From: David Gallimore [REDACTED]
Sent: 04 May 2020 17:04
To: Paul Cann <Paul.Cann@arun.gov.uk>
Cc: Mike Griffin [REDACTED]; Sarah Burrow <Sarah.Burrow@arun.gov.uk>; Planning.Responses <Planning.Responses@arun.gov.uk>; Michael Eastham <Michael.Eastham@arun.gov.uk>
Subject: RE: Planning Consultation on BE/21/20/DOC

From: Paul Cann <Paul.Cann@arun.gov.uk>
Sent: 21 April 2020 12:02
To: Planning.Responses <Planning.Responses@arun.gov.uk>
Cc: Sarah Burrow <Sarah.Burrow@arun.gov.uk>
Subject: RE: Planning Consultation on BE/21/20/DOC

APPLICATION NO: BE/21/20/DOC

Site Address: Land At Salt Box West Of Shripney Road Bognor Regis PO22 9NW

HYDROCK PROJECT NO.		SCALE @ A1
C-13319-C		1:250
STATUS DESCRIPTION		STATUS
TENDER		D2
DRAWING NO. (PROJECT CODE-ORIGINATOR-ZONE-LEVEL-TYPE-ROLE-NUMBER)		REVISION
SAL-HYD-PH2-ZZ-DR-C-7010		P03

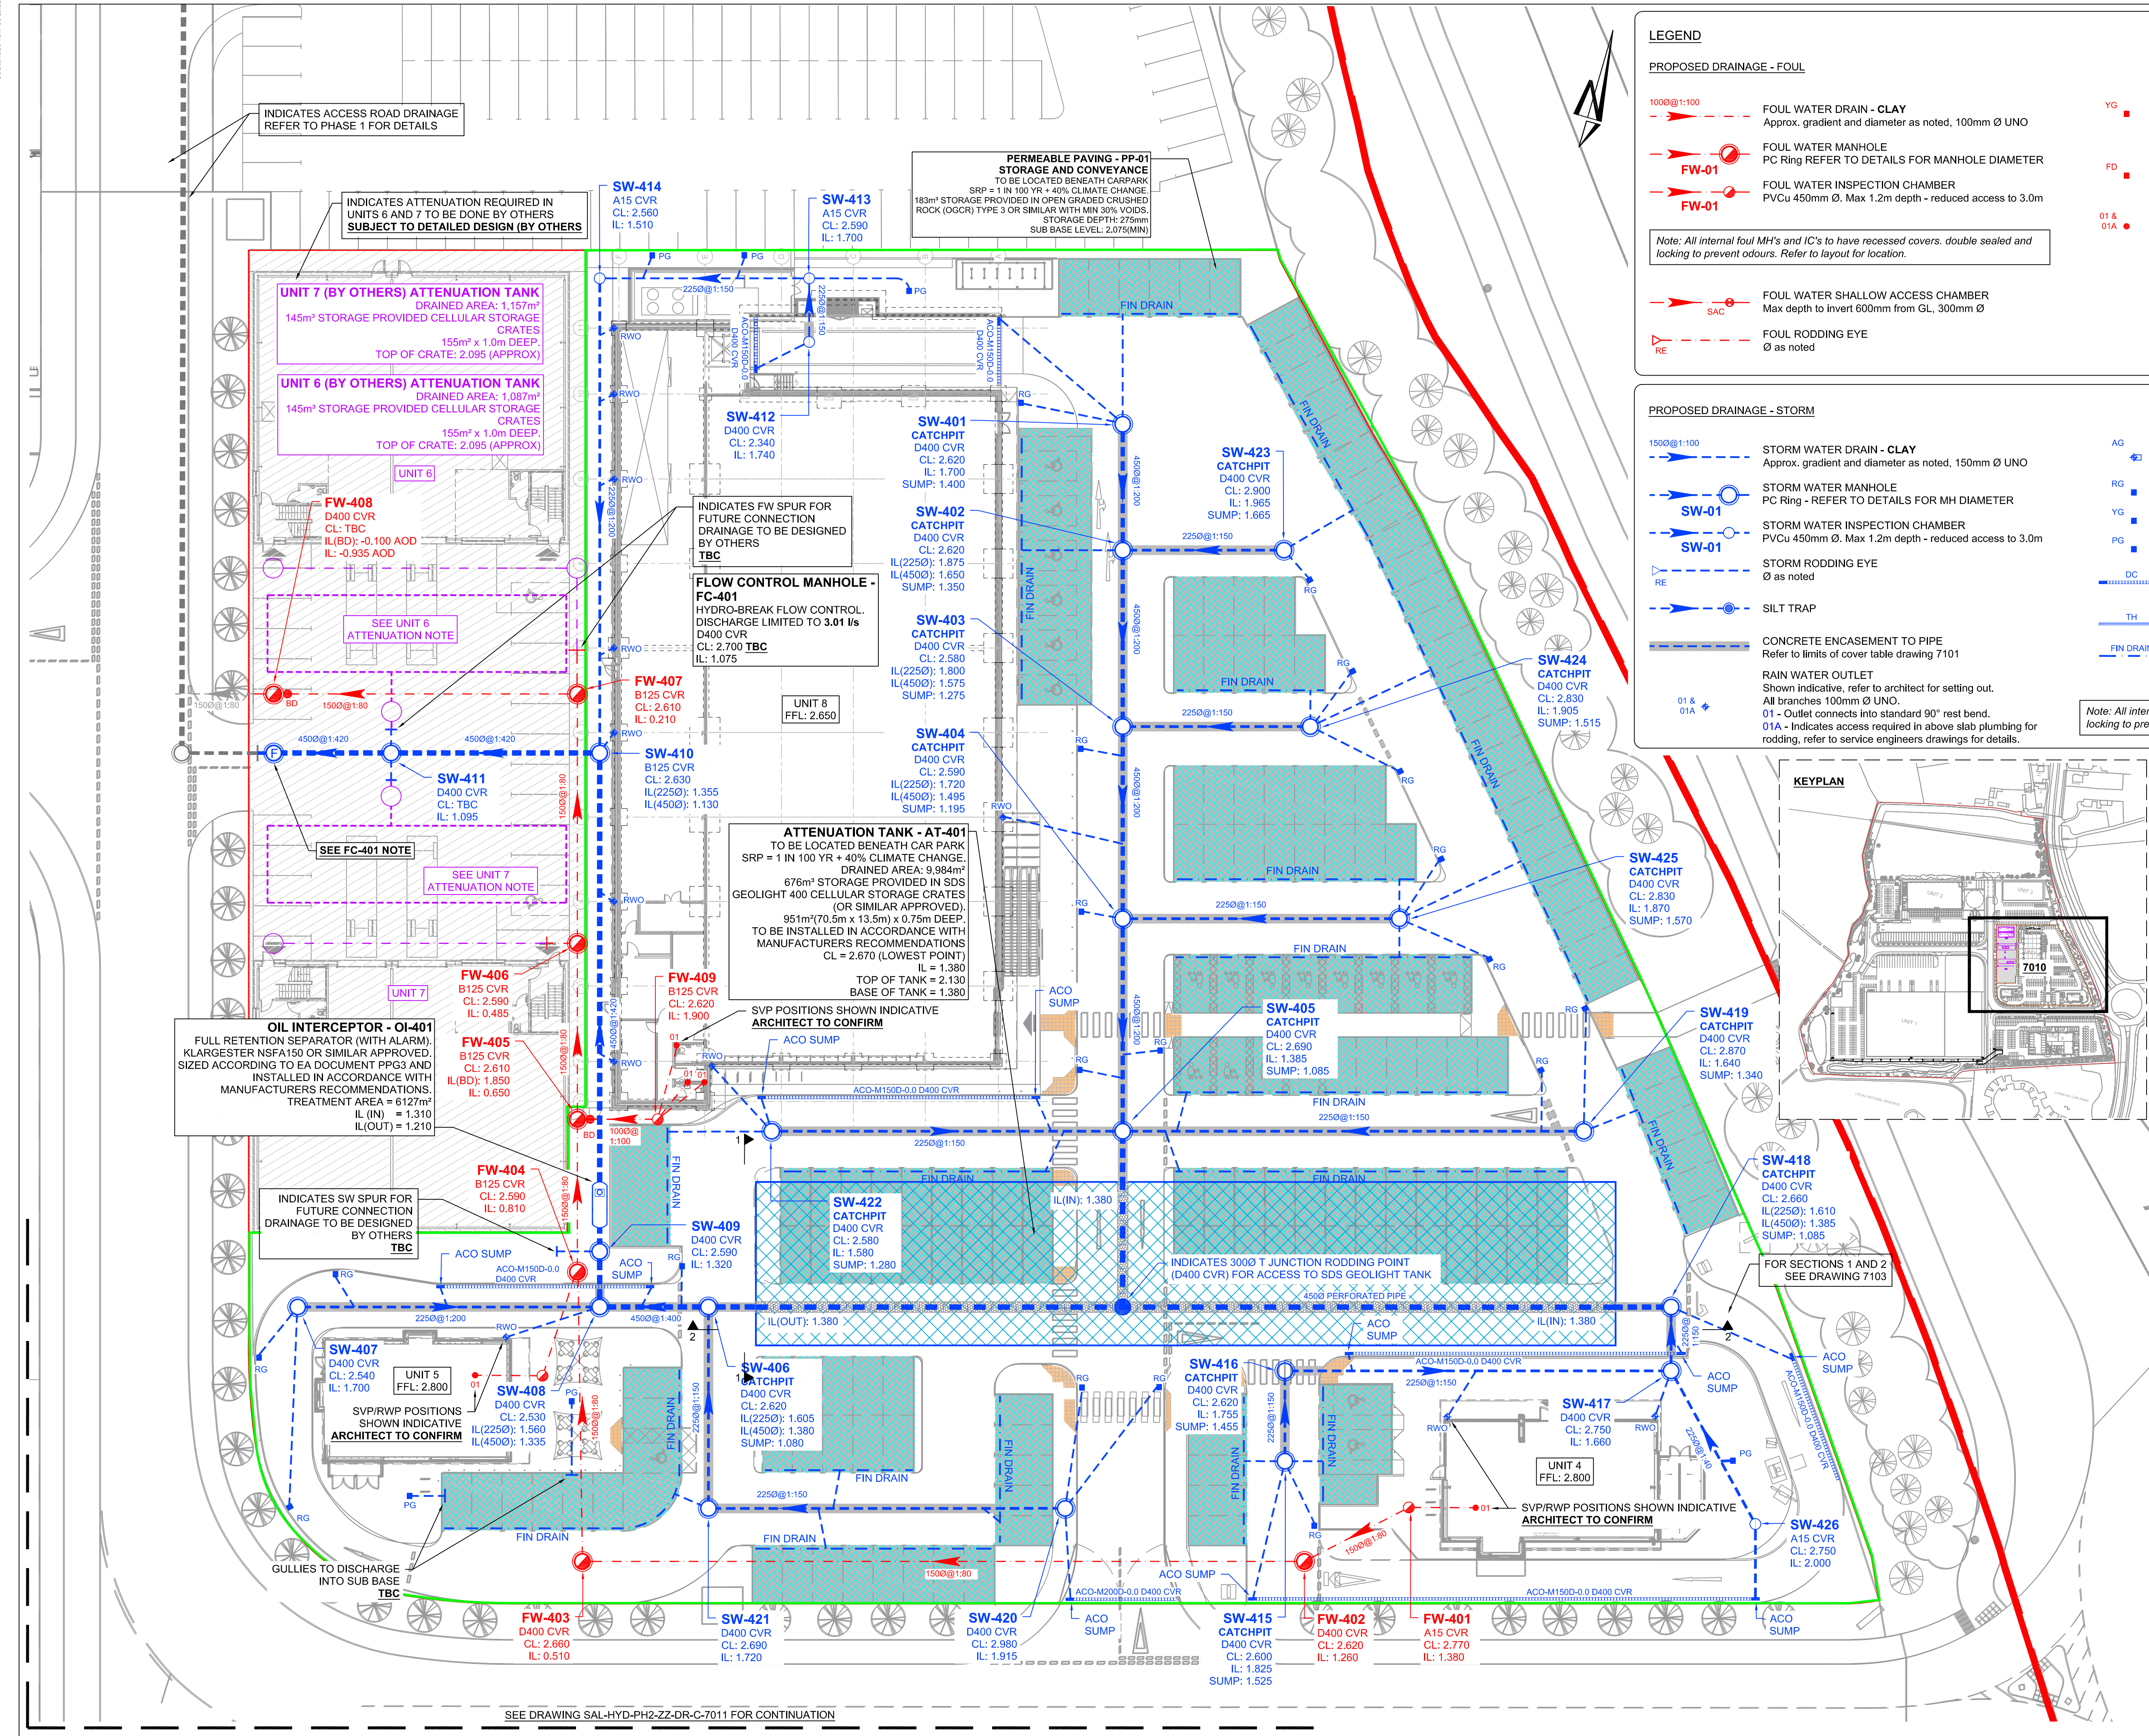
14. Drawing 7010 – specify sub base levels for ALL permeable paving areas. On drawing 7300 – add note to refer to sub base levels on drawing 7010.
Sub base levels added To 7010 and note added to 7300.

15. Drawing 7010 - SW-405 to tank – specify pipe diameter and a reasonable gradient.
Gradient added
16. Drawing 7103 (Phase 2)– Section 2-2 – should this be labelled AT-401?
401 label added.

HYDROCK PROJECT NO. C-13319-C		SCALE @ A1 1:250	
STATUS DESCRIPTION TENDER			STATUS D2
DRAWING NO. (PROJECT CODE-ORIGINATOR-ZONE-LEVEL-TYPE-ROLE-NUMBER) SAL-HYD-PH2-ZZ-DR-C-7011			REVISION P03

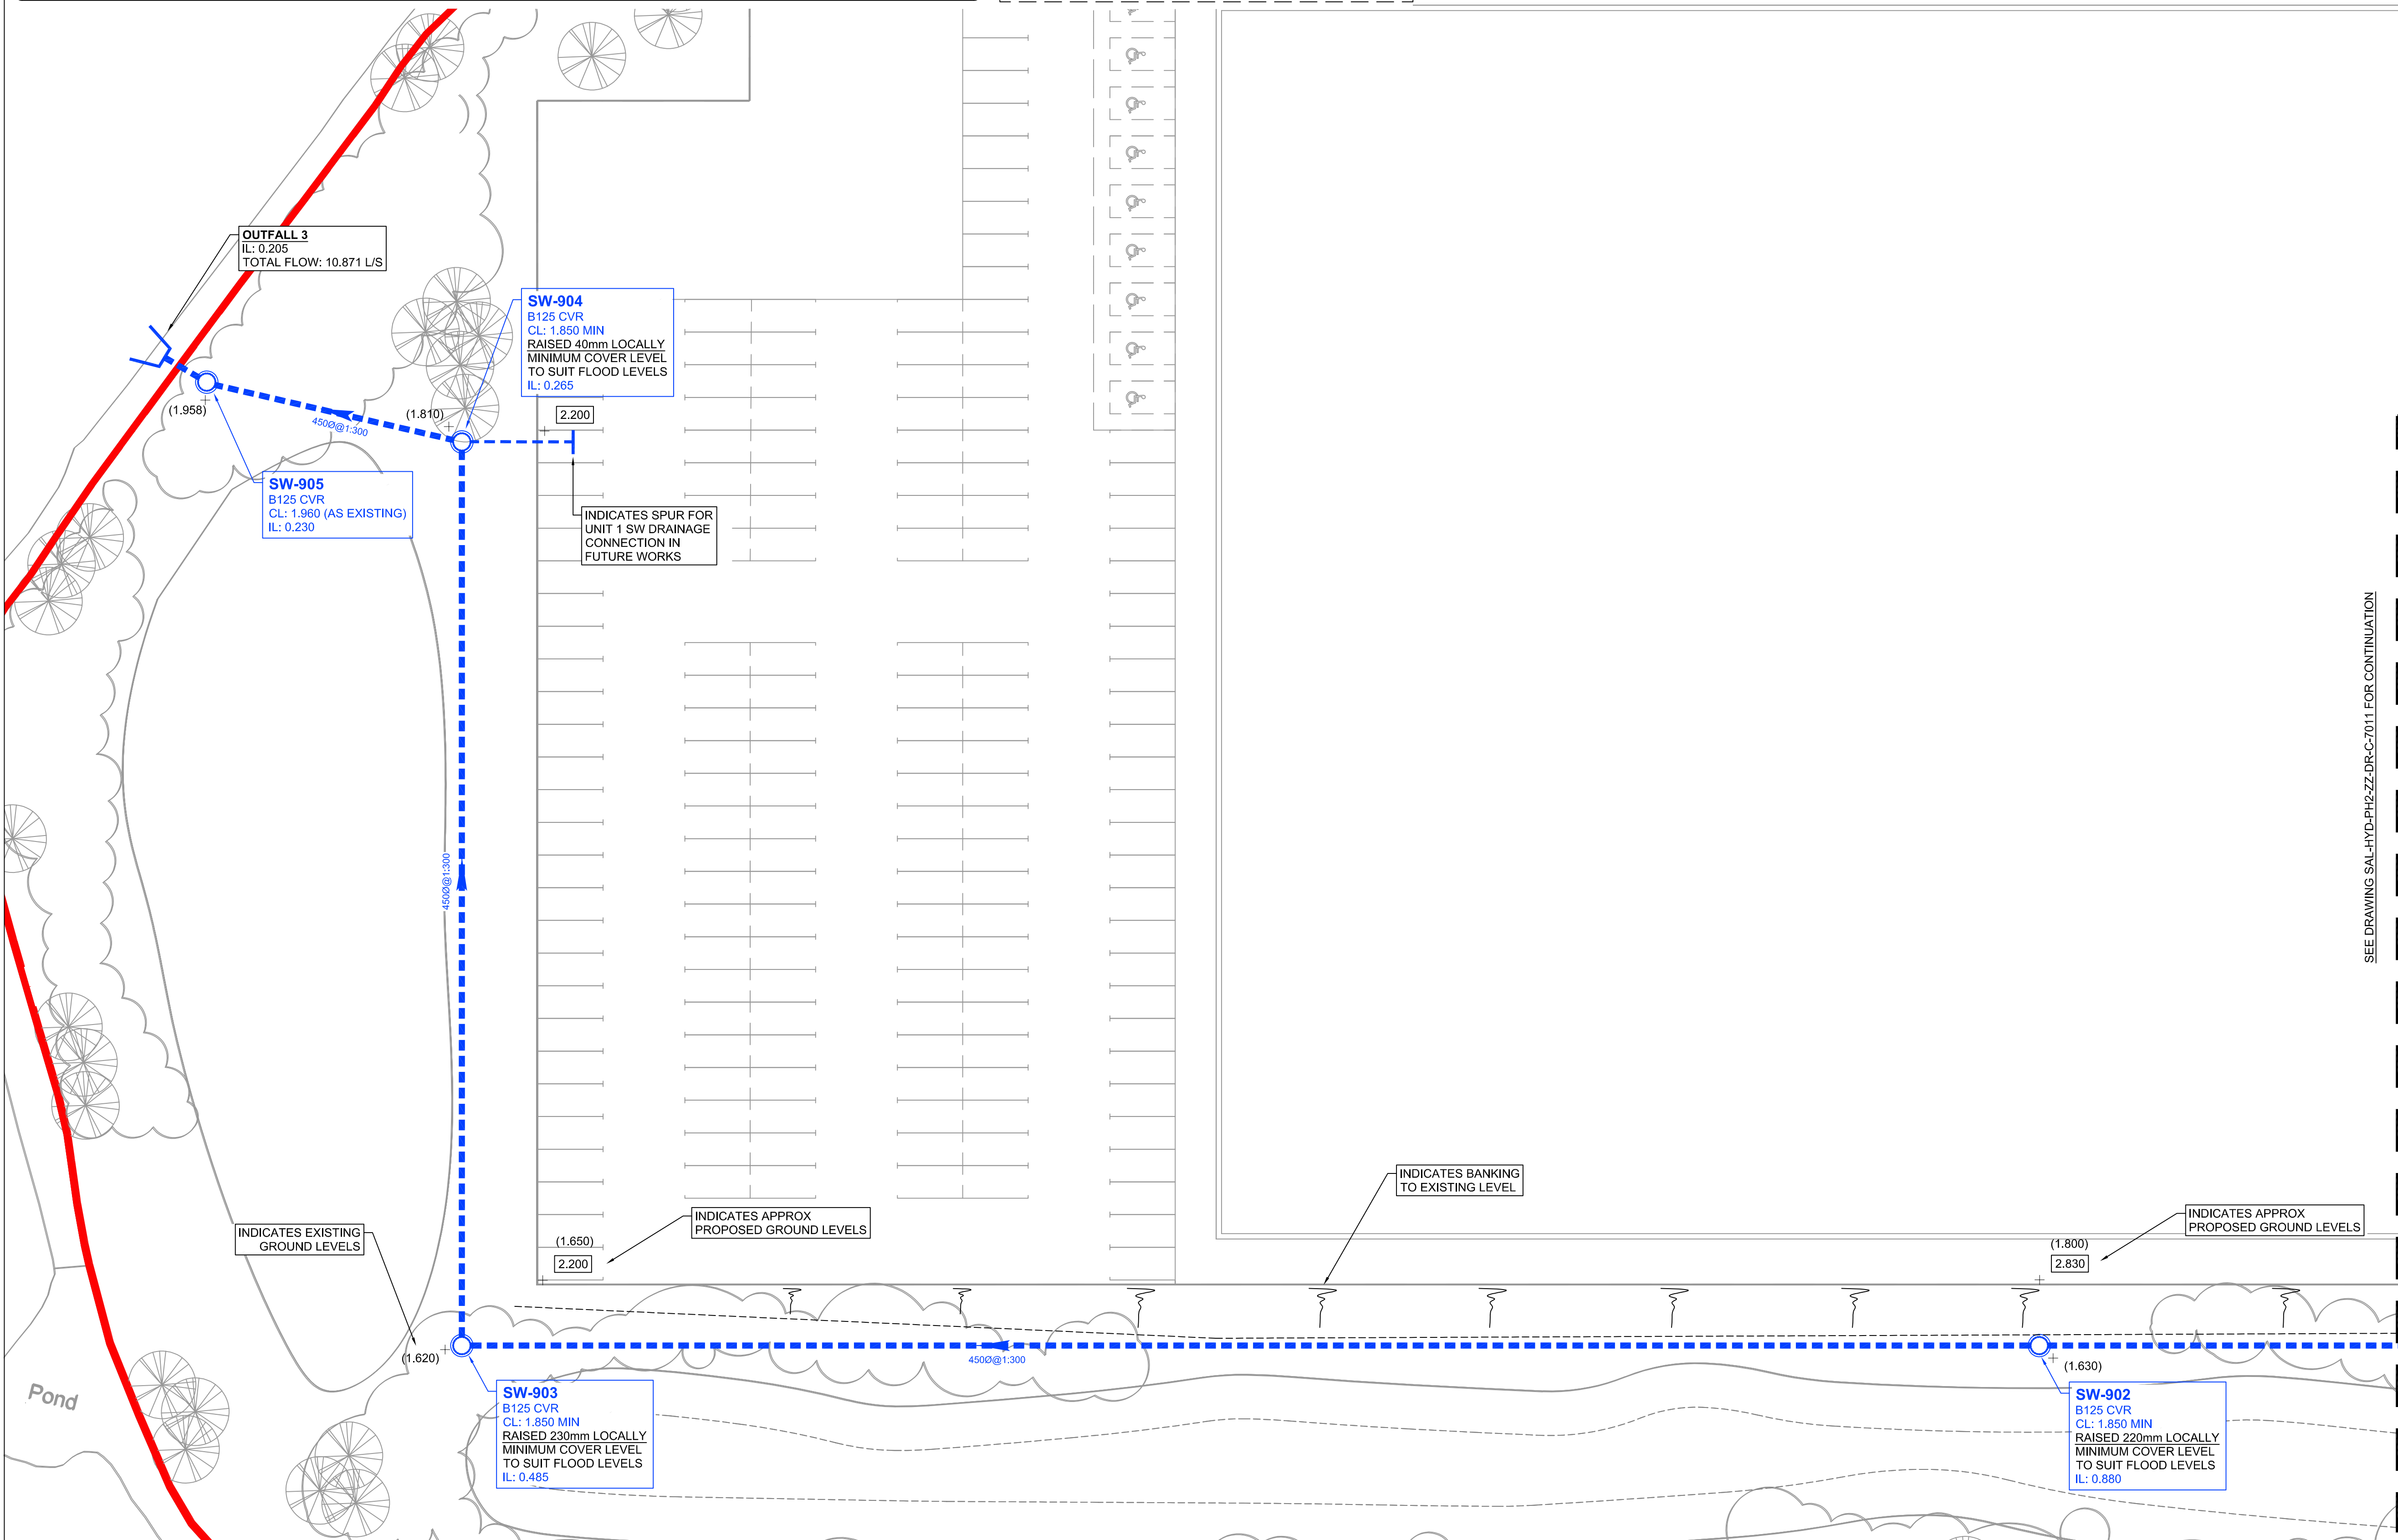
7. Manhole SW-900 invert level is different on plans 7011 and 7022. Noted.
PH1-7022 IL revised to suit PH2-7011.

9. Drawings 7011 and 7012 – Remove any trees etc being shown within proximity of the proposed pipeline.
Noted. Trees removed.
10. Improve gradient FC-401 to 01-401 to min 1 in 400.
Pipe gradient updated.

DETAIL PG: PAVED GULLY
SCALE 1:10

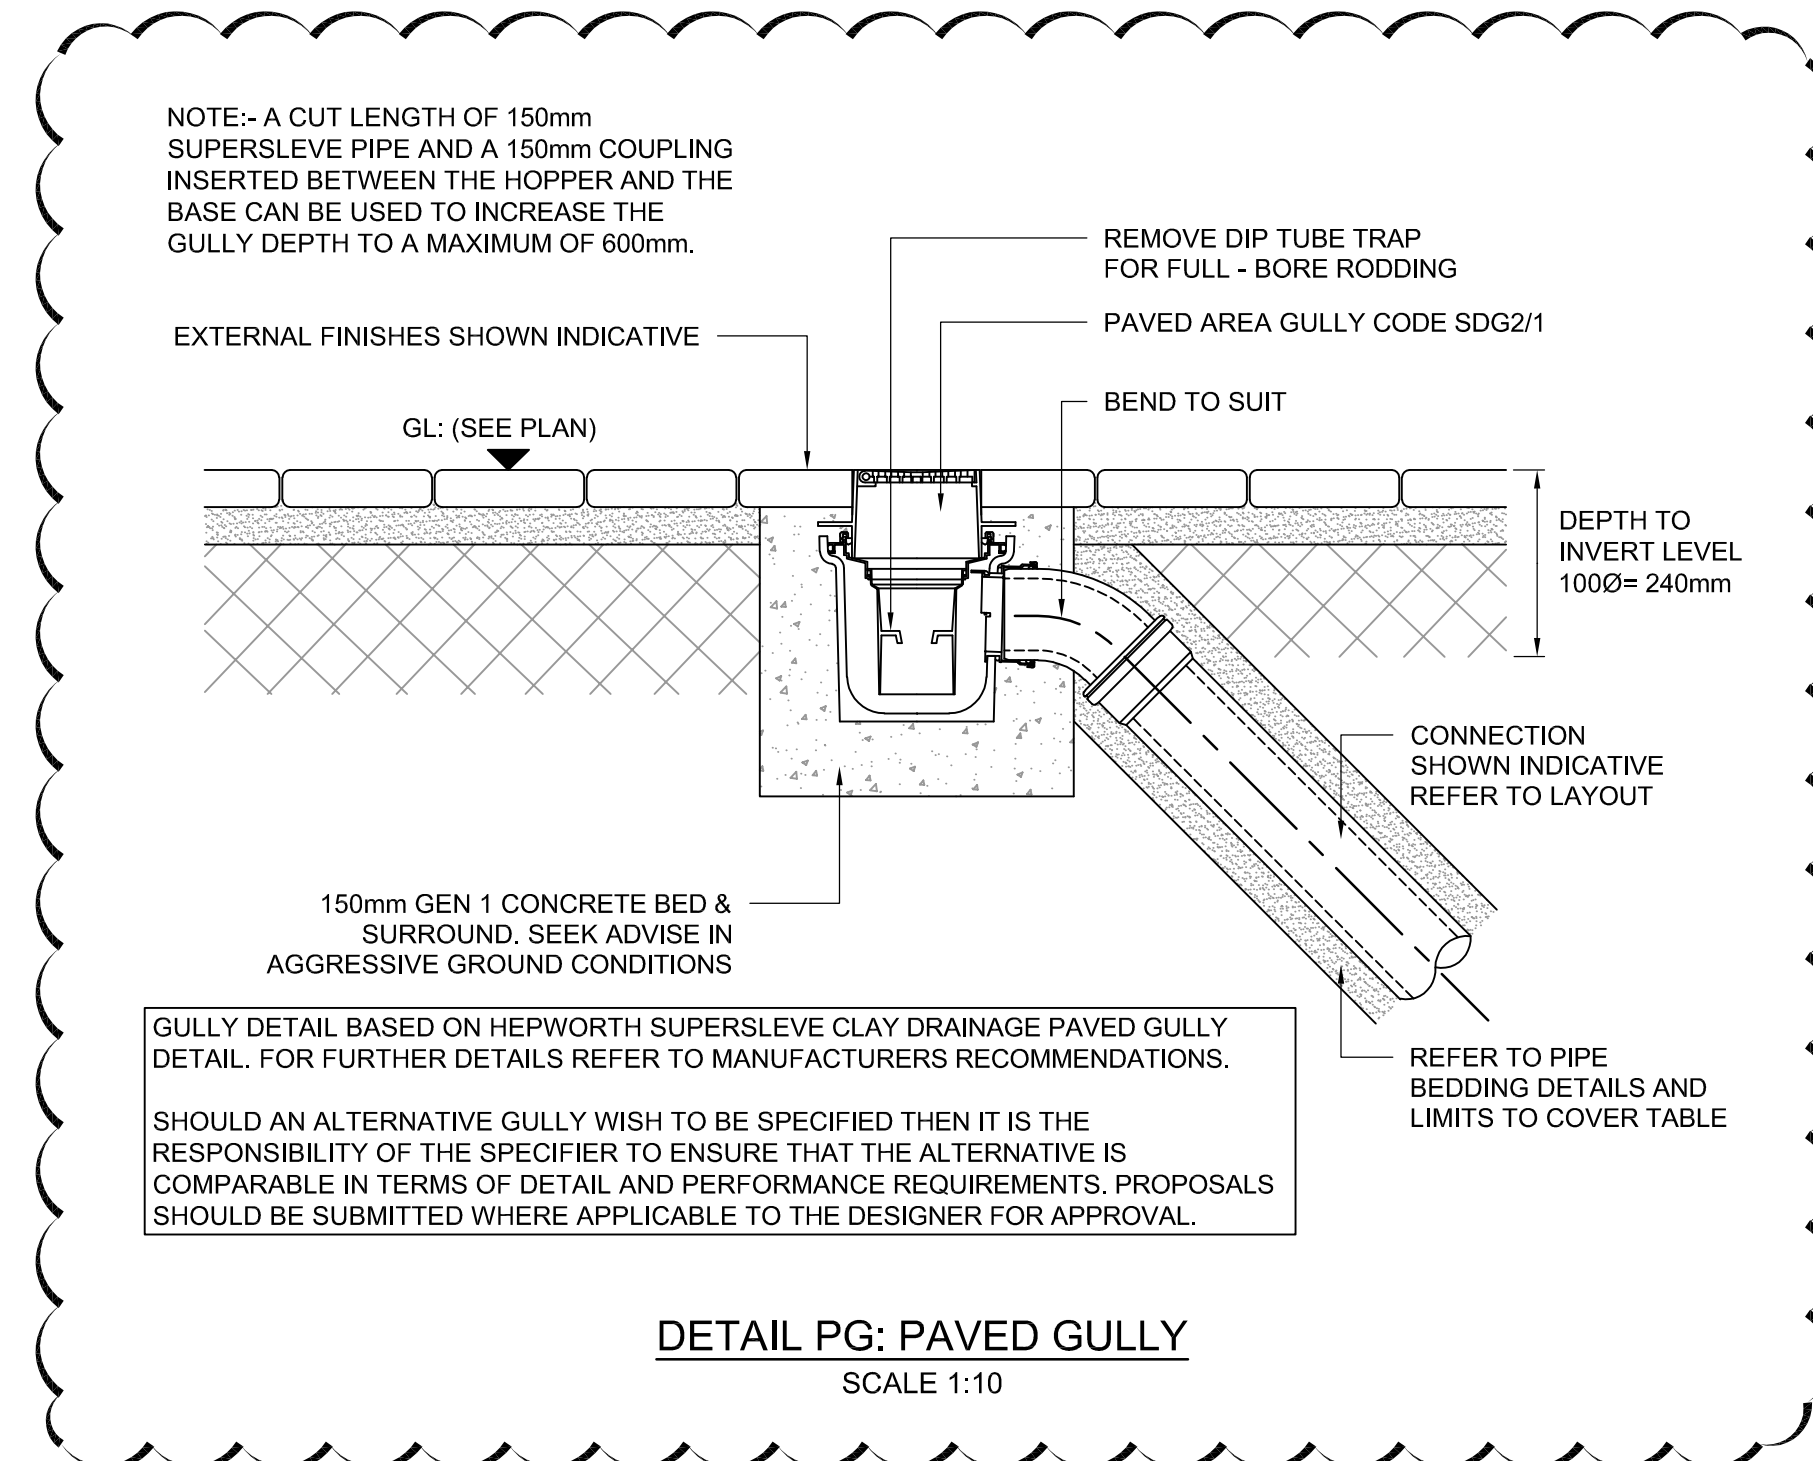
11. Specify gradient and pipe diameter (FC-401 to SW-1000) on drawings 7010 and 7021.
Pipe gradient added
12. Provide PG paved area gully construction detail (to incorporate silt trap).
PG detail added
